**The Sizewell C Project Development Consent Order Application
Planning Inspectorate Reference: EN010012**

Relevant Representation from the Royal Society for the Protection of Birds

30 September 2020

DRAWING TITLE:
 LOCATION PLAN OF THE SSSI CROSSING

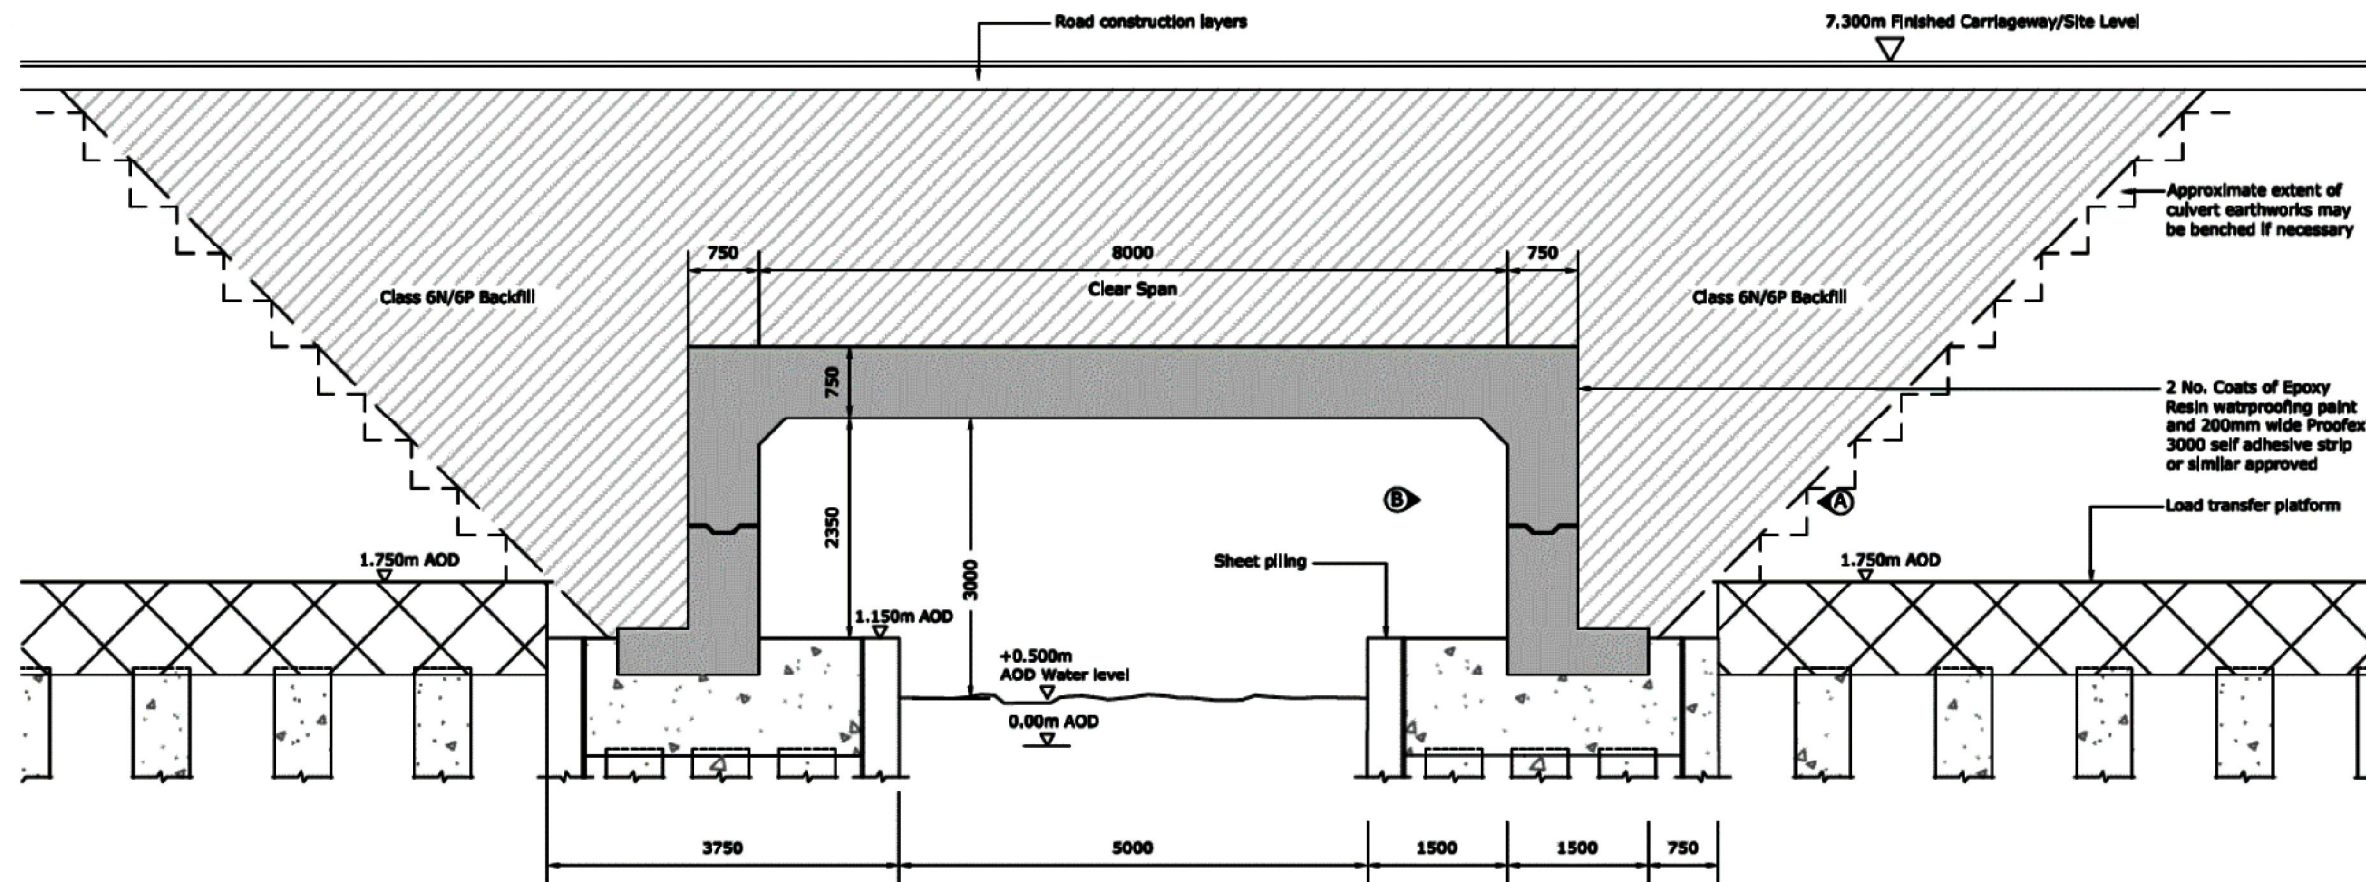
- Detailed designs for key features including the coastal defences and crossing over the Sizewell Marshes Site of Special Scientific Interest (SSSI) are missing and we cannot therefore have confidence in the assessments of their potential impacts;
- Conclusions of no adverse effect on integrity (AEOI) of European Protected sites are in many cases reliant on mitigation and monitoring plans which have not yet been produced, again leading to a lack of confidence in these conclusions;
- The Shadow Habitats Regulation Assessment³ does not assess the *total impacts* of the project on the European Protected sites and their designation habitats and species. Although each type of potential impact is assessed (but please note the two bullet points below) this is done separately. This means conclusions regarding the total potential effects on the *integrity of the sites* is incomplete;

DRAWING TITLE:
 CROSS SECTION THROUGH THE SSSI
 CROSSING CULVERT

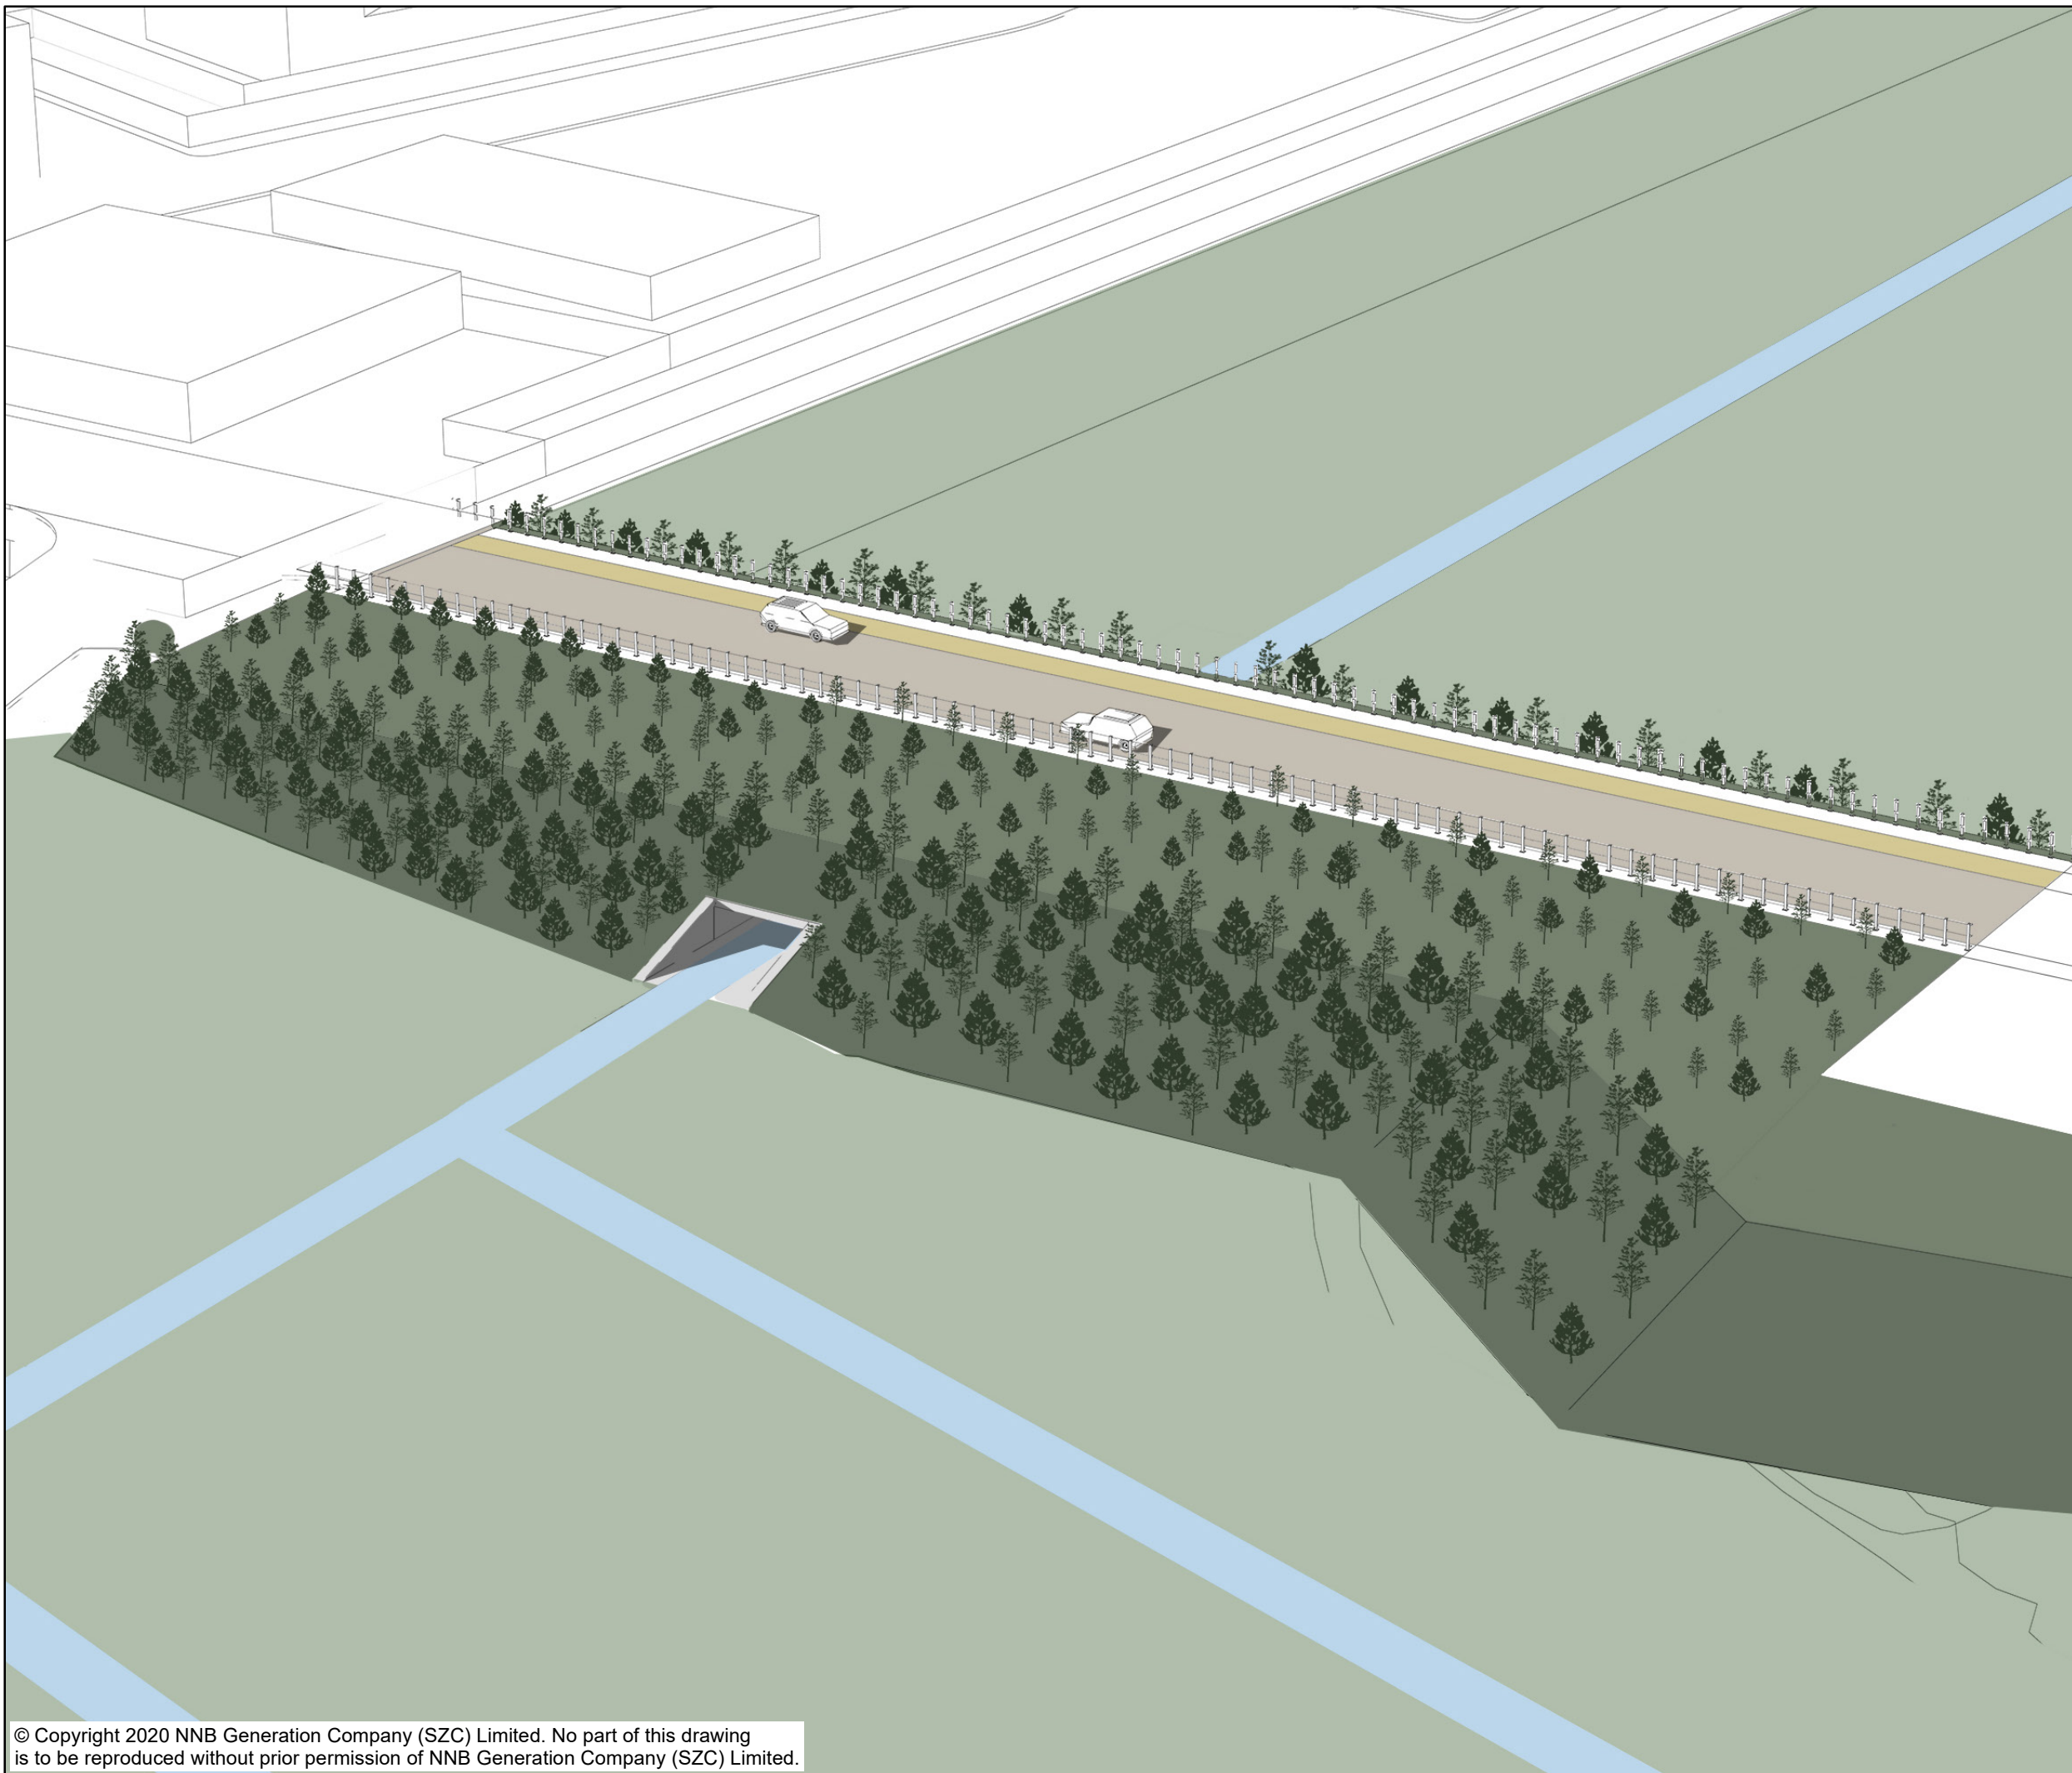
- The principle of the proposed loss of part of Sizewell Marshes SSSI and its assessment against the tests set out in EN-1 (Overarching NPS for Energy) including the justification for the choice of an embankment and culvert rather than a bridge to cross Sizewell Marshes SSSI (despite the higher land take from the SSSI);
- The total area of loss from Sizewell Marshes SSSI and the designation of some loss as "temporary", which has not been supported by proposals for adequate restoration methods; and
- Concern about adequacy of the proposed habitat compensation in terms of quantity and quality of all affected habitats.
